# CITY OF ALBUQUERQUE

**Re: Second Non-compliance for Concrete Wash-out and no Concrete Wash-out Station at Del Norte Dialysis Clinic; eNOI Tracking Number NMR12B711**

1 CONCRETE WASHOUT CONTAINMENT DETAIL SCALE: 1/8" = 1'-0"

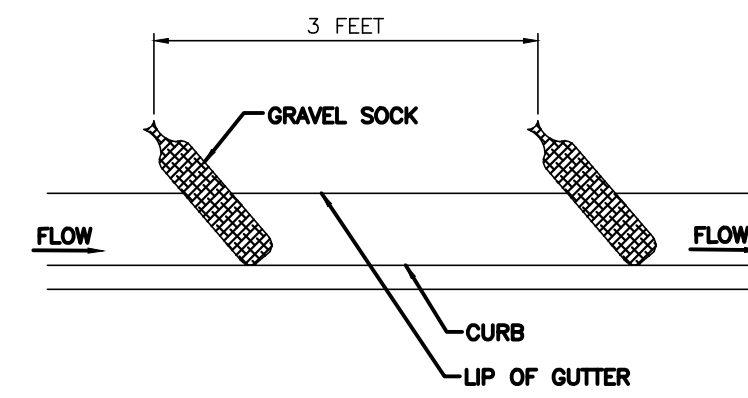
On June 26th, 2015 you were informed of your NDPES CGP non-compliance due to a lack of a concrete washout station and concrete wash-out in numerous locations.

I visited the site today and the same non-compliance issues were present.

You have seven days to have a concrete wash-out station on site and to clean up the current concrete wash-out areas or your non-compliance will be reported to the New Mexico Environment Department, Surface Water Quality Bureau to aid in the determination if this issue is to be forwarded to the EPA.
